Your Ref	SSD-84699461
Our Ref	NCA/16/2025
Contact	Douglas Bennett
Telephone	02 9806 5405
Email	dbennett@cityofparramatta.nsw.gov.au

COUNCIL SUBMISSION TO REQUEST FOR ADVICE ON ENVIRONMENTAL IMPACT STATEMENT – MIXED-USE DEVELOPMENT WITH IN-FILL AFFORDABLE HOUSING (SSD-84699461) AT 241-245 PENNANT HILLS ROAD, CARLINGFORD

The proposal has been designed to provide the following setbacks:

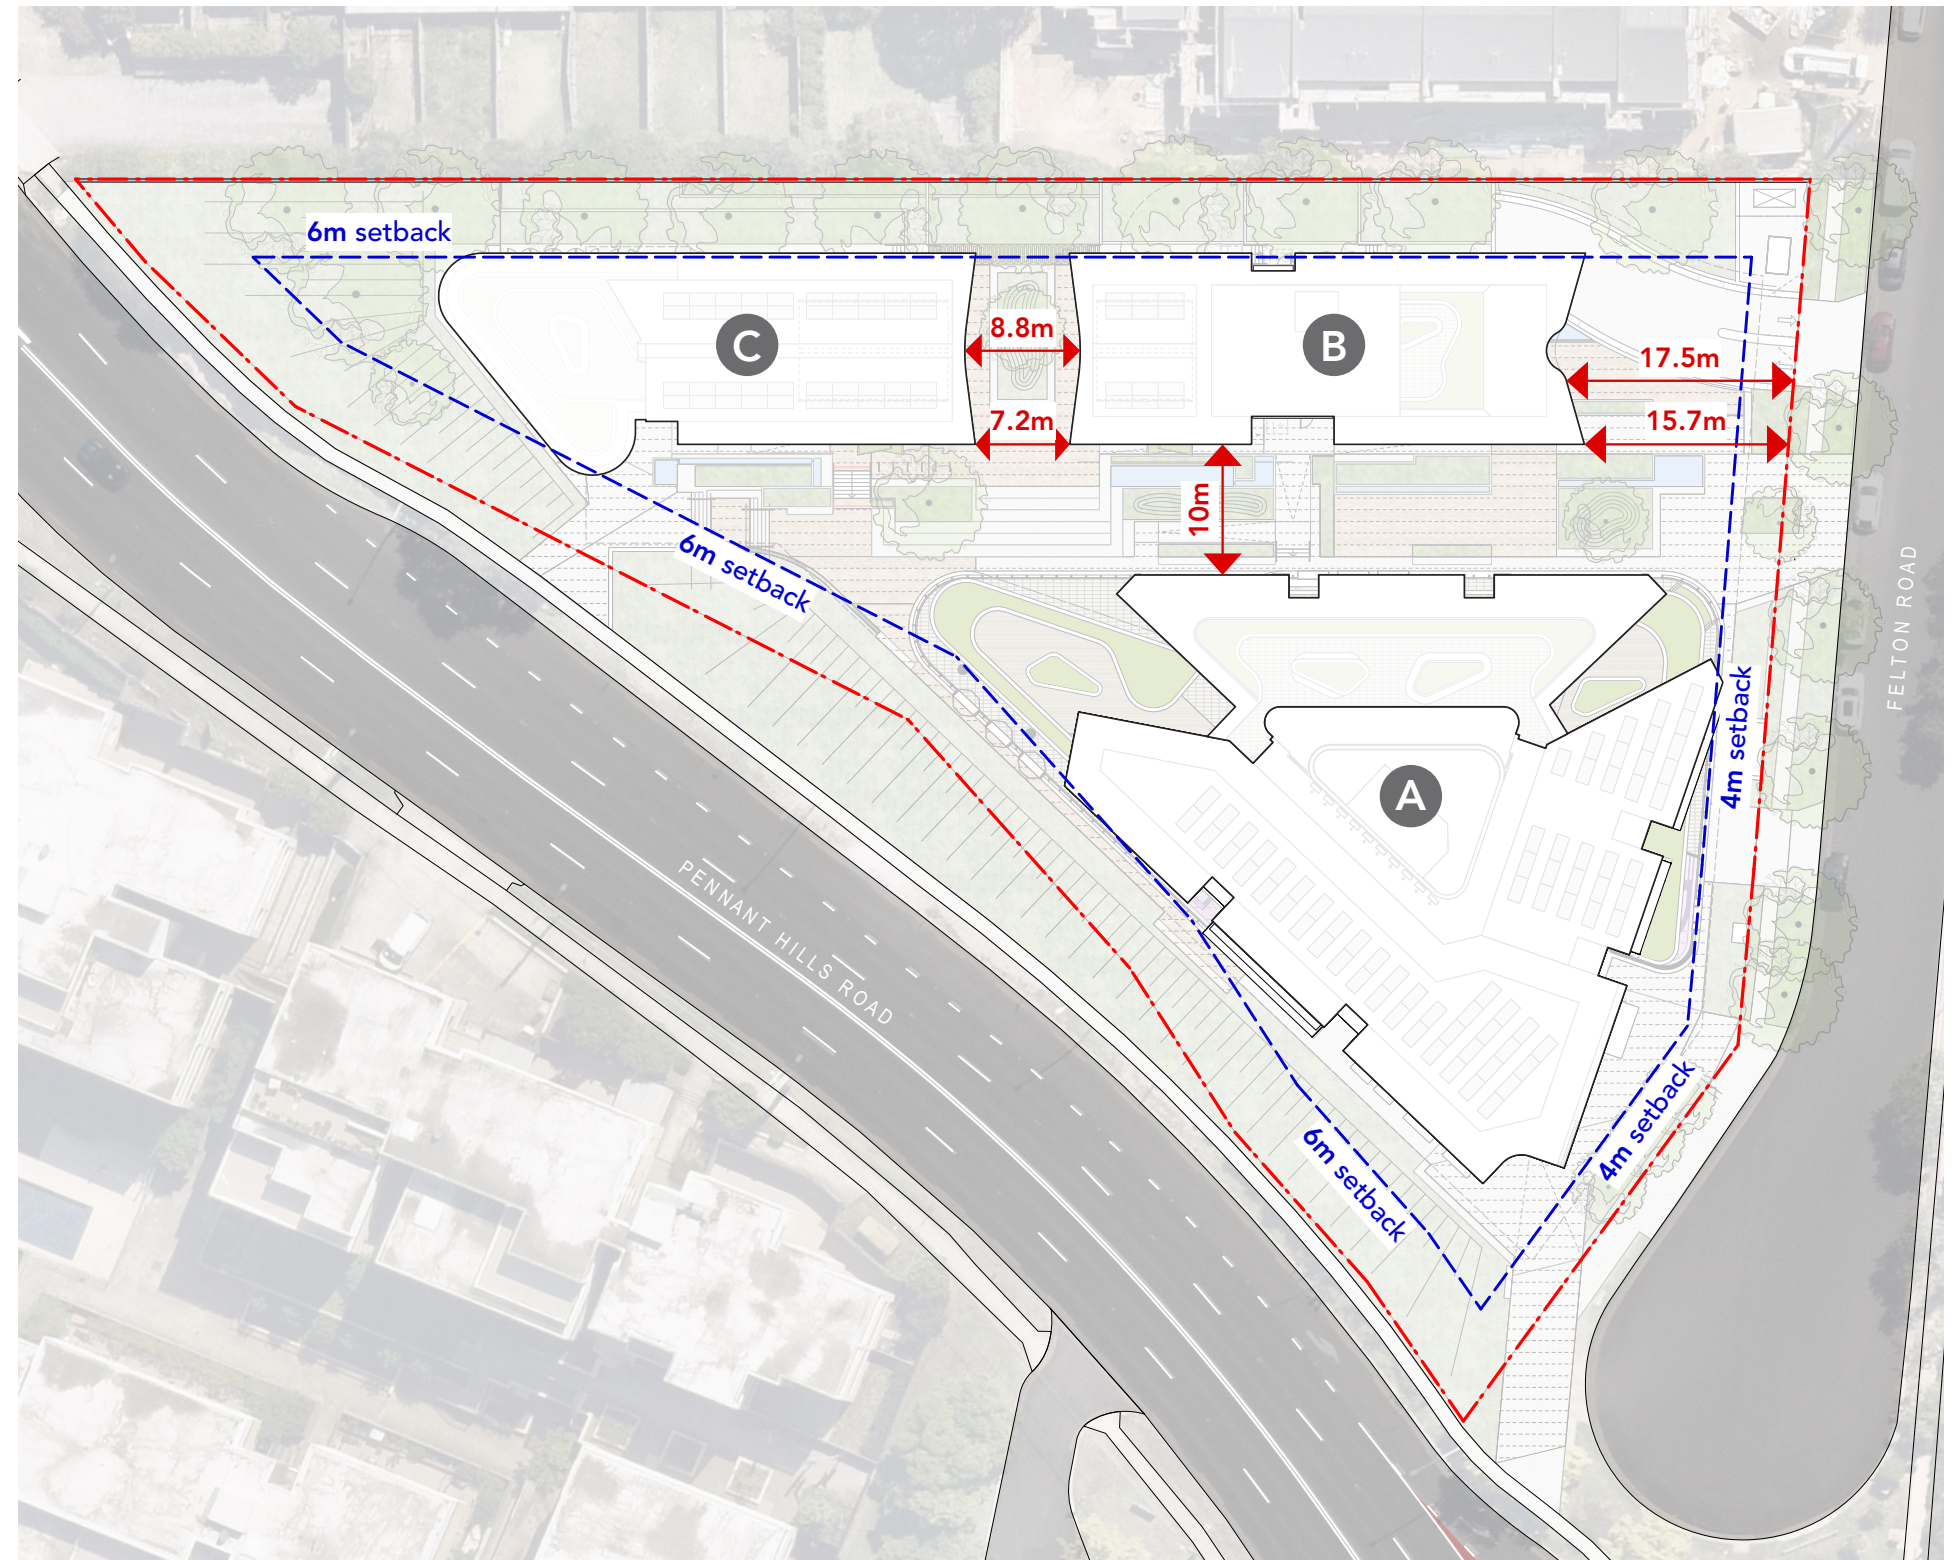
A 10-metre front setback is required along Pennant Hills Road, which is being applied consistently to recent development proposals on this corridor including large mixed-use schemes such as the site further to the north (263-281 Pennant Hills Road, Carlingford). This setback must be measured from the future property boundary, accounting for the land that will be acquired as part of the TfNSW road widening program. When the ultimate boundary is considered, the current scheme positions the building too close to the street, and the footprint will need to be adjusted to achieve the required setback.

Retaining only 6 m at the primary frontage limits the ability to establish a robust landscape buffer, constrains opportunities for large canopy trees, and results in an excessive built interface with the major arterial road. In addition, the reduced setback reduces the amenity and usability of balconies facing Pennant Hills Road due to excessive noise emissions and pollutants.

The proposed building line to Felton Road varies across the frontage, but key portions reduce to approximately 4 m, which is insufficient to support deep soil planting, limit visual bulk, or provide appropriate separation to the adjoining Ausgrid Transmission Substation site. A minimum 6 metre setback is recommended along Felton Road to accommodate large canopy trees and meaningful buffer planting, improve the spatial transition to the school frontage opposite, and strengthen the relationship between the built form and the adjacent infrastructure corridor. Street trees should be planted at 8-10m along this street frontage. Species should match the existing *Ficus* species down the street in front of the school. A new 1.5m wide concrete footpath at the property boundary with a turfed verge should also be provided.

A 6 m western setback is shown in the design, which in principle provides a reasonable transition to the neighbouring residential properties. However, this setback is undermined by the basement extending to the boundary, preventing deep soil and limiting the ability to plant larger species. To achieve a functional buffer zone and a more appropriate interface, the setback should remain clear of basement and driveway structures, allowing for a continuous deep soil zone, native tree planting to provide privacy screening, and a softer, compatible edge condition.

floor plans - ground floor to level 01

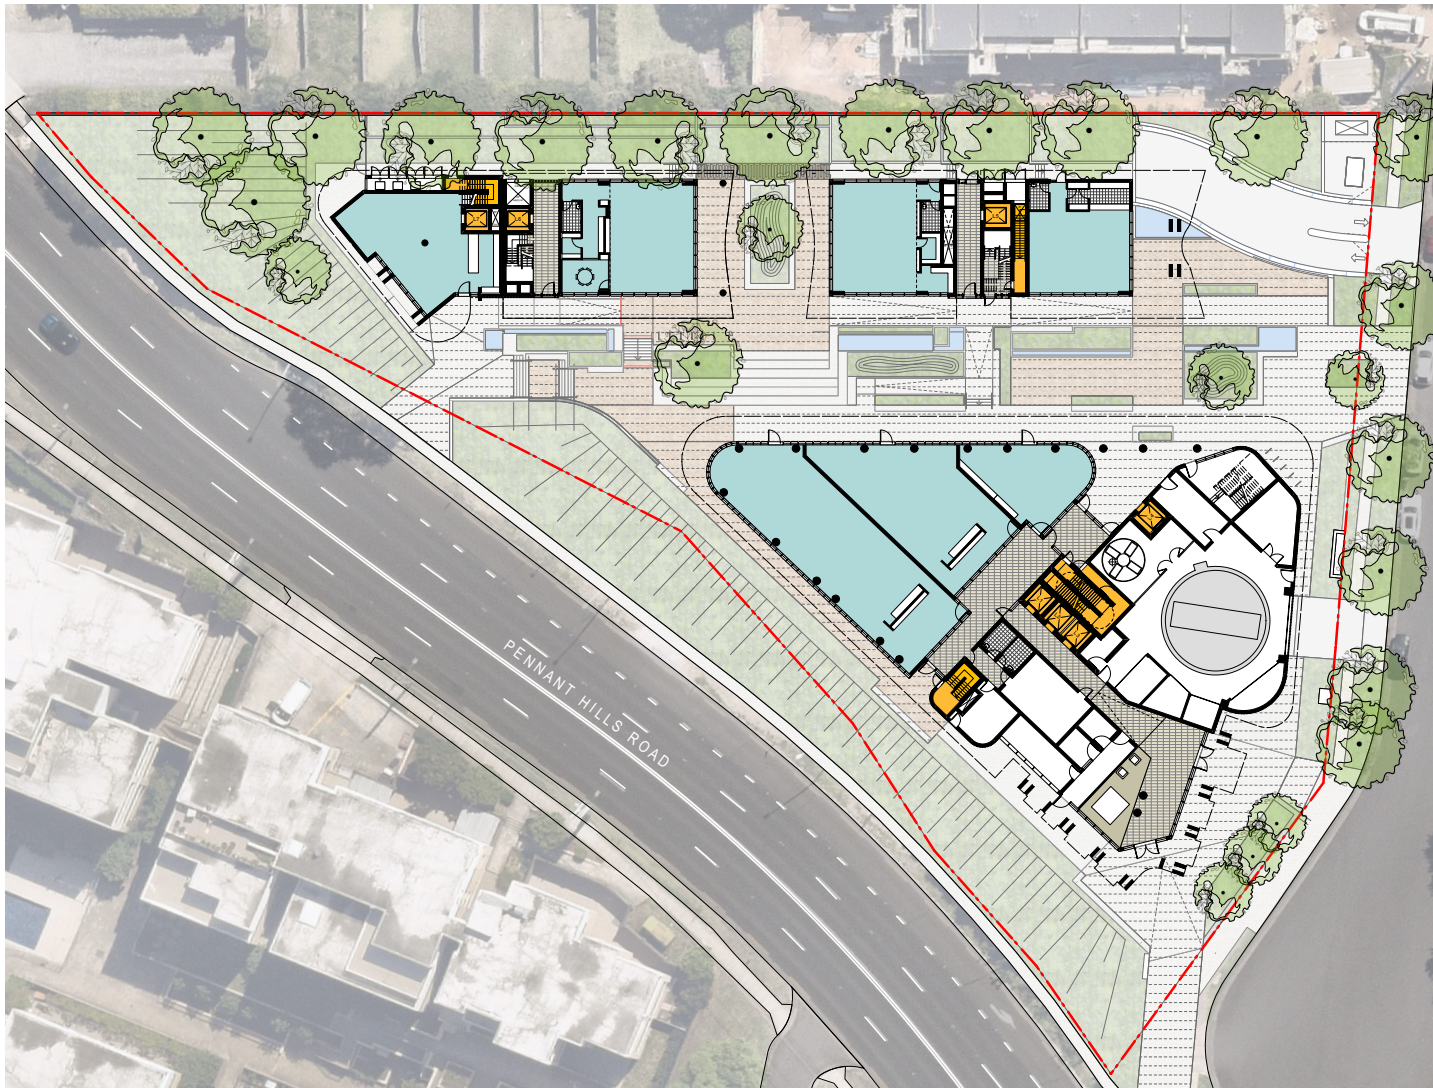
Building & Level	Component	Area (estimate)	Comment
Ground, Building A	Waste storage areas. 	152.5sqm	As per the definition of gross floor area, only basement garbage/waste areas are excluded from counting towards gross floor area. The several waste storage areas located at the ground floor of Building A must therefore be counted as gross floor area.
Ground – Level 1, Building A	Childcare foyer & stairs	35.6sqm	The childcare foyer area has been erroneously excluded from GFA
